TfNSW Reference: SYD15/01390/18

DPI&E Reference: SSD 7348 MOD 2

**MODIFICATION TO CONCEPT PLAN AND STAGE 1, OAKDALE WEST INDUSTRIAL ESTATE– ERSKINE PARK**

TfNSW has reviewed the modification application and provides the following comments for your consideration in the determination of this application:

ACCESS AND CIRCULATION

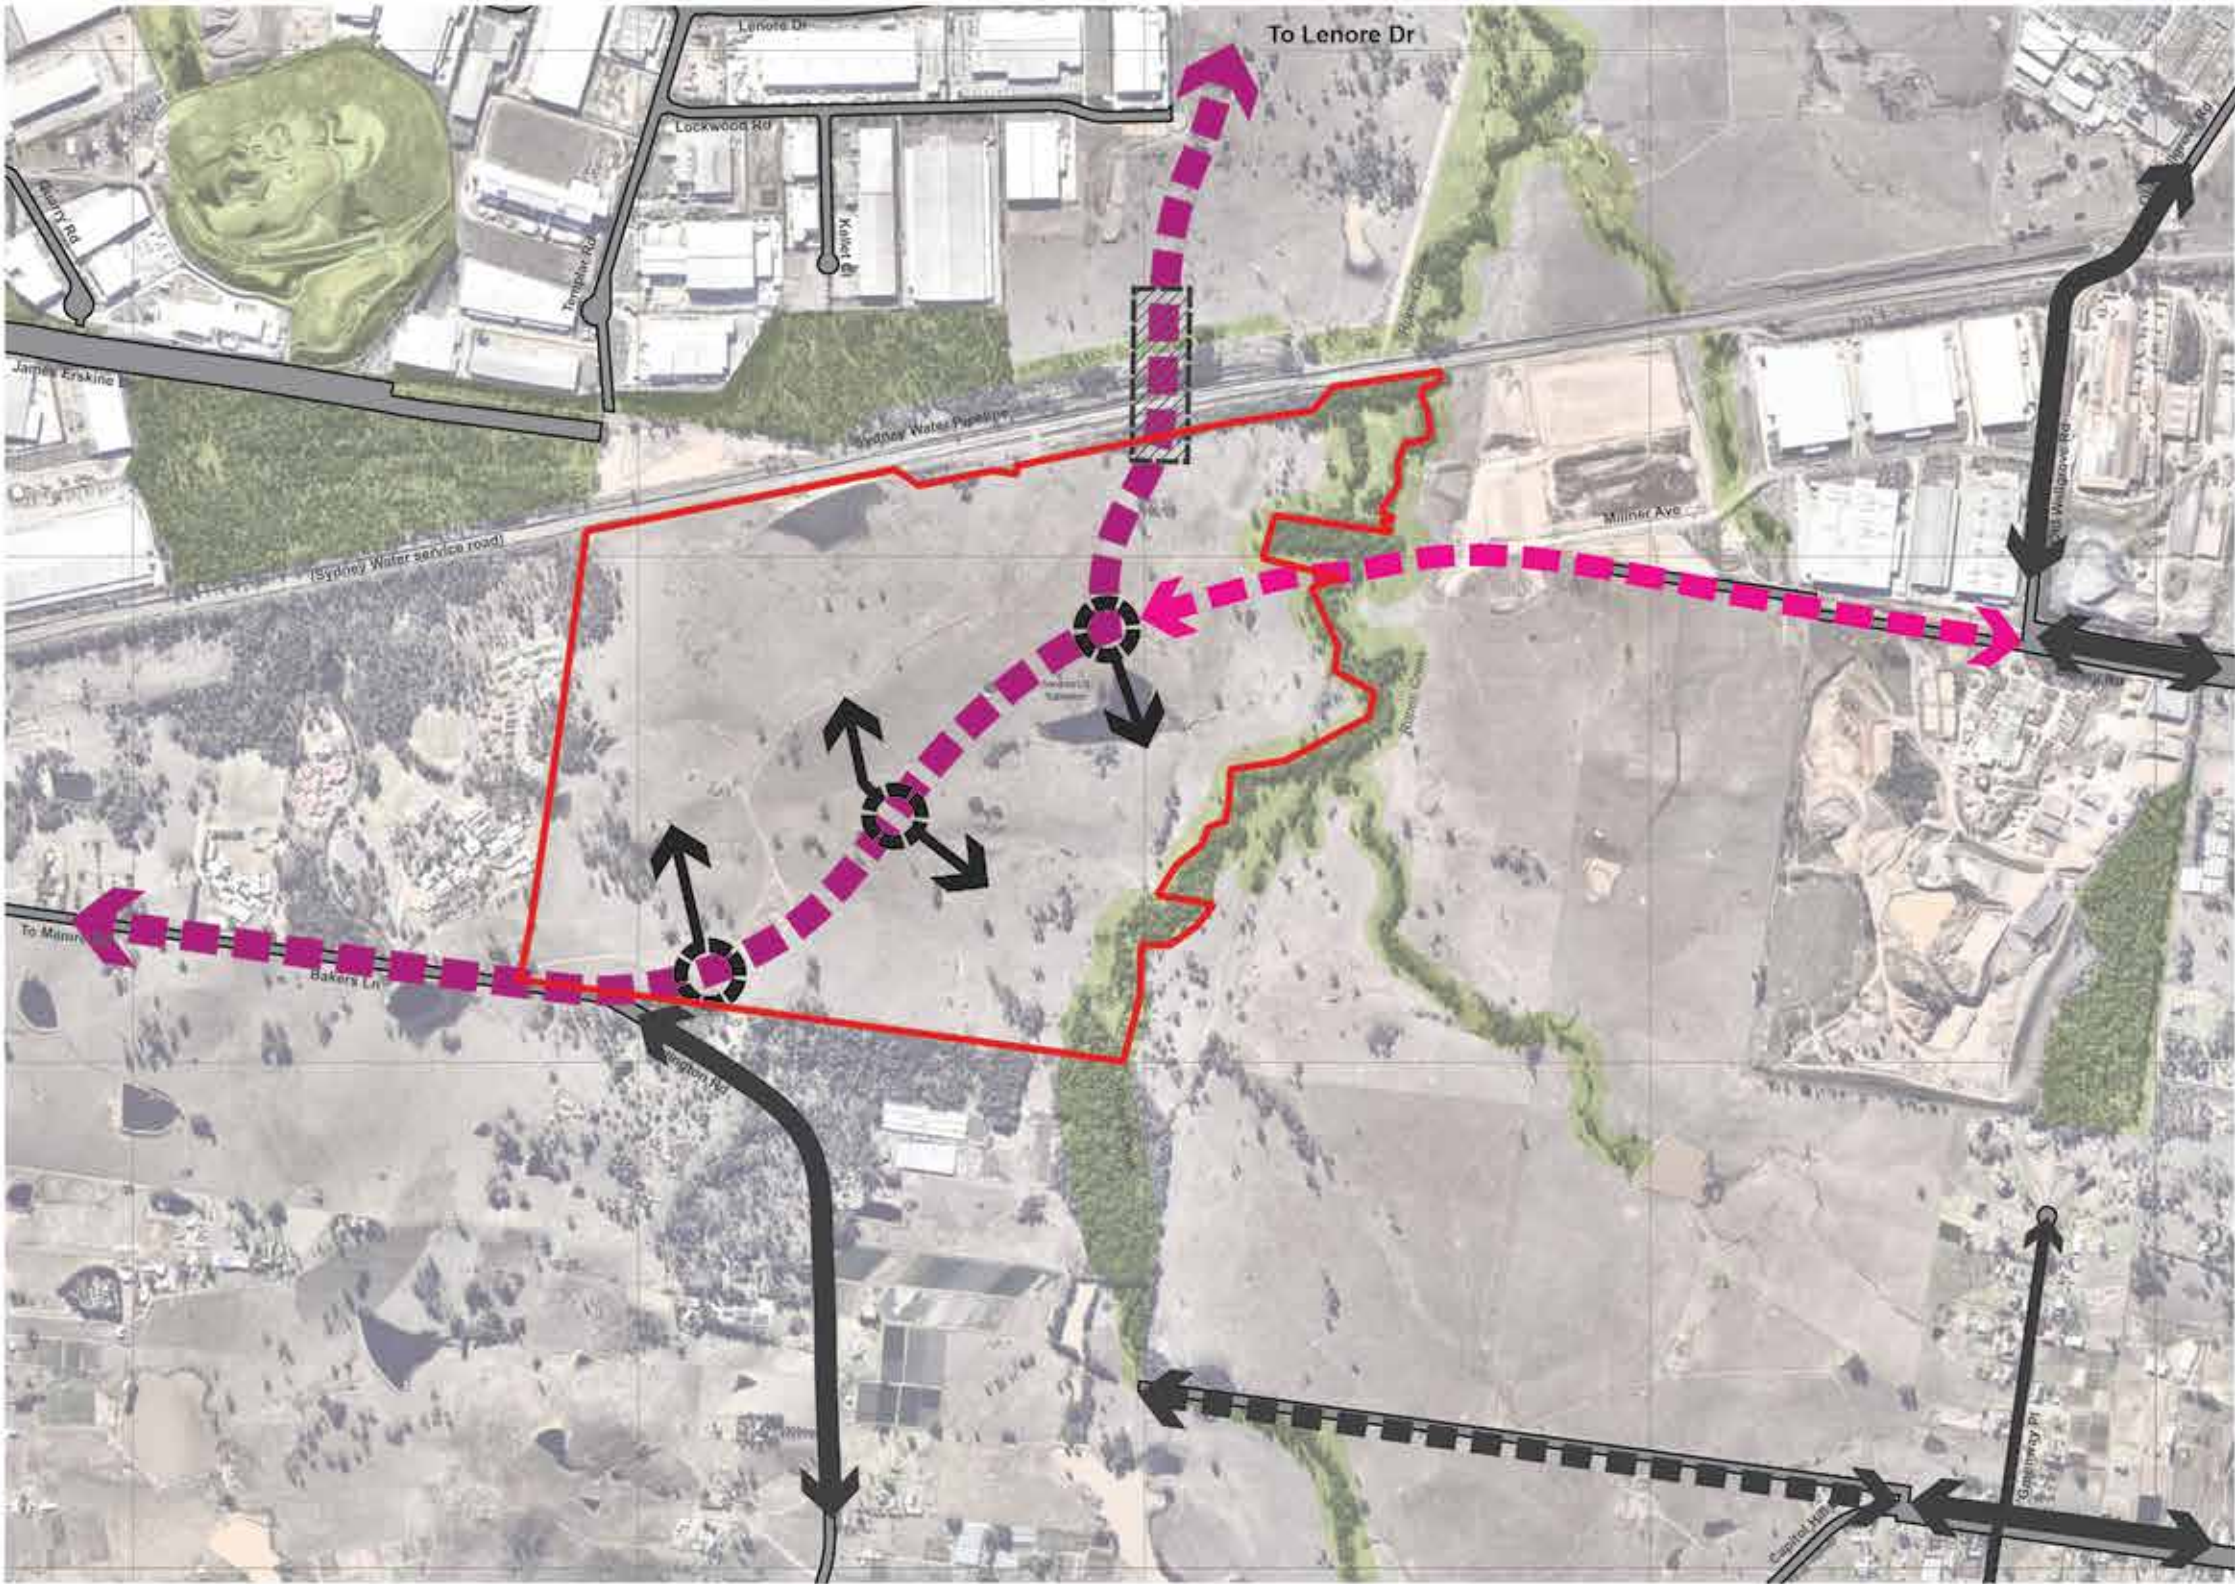
1. TfNSW provided comments on 11 November 2019 regarding the requirements for the freight line corridor preservation and it remains applicable.
2. The previous TfNSW comments dated 13 February 2019 and 12 June 2019 also remain applicable.
3. Vehicular access on the new local roads should not be located within close proximity to future traffic signals on the Southern Link Road for efficiency and safety reasons.
4. Automatic vehicular access gates should be removed along the Western North South Link Road.
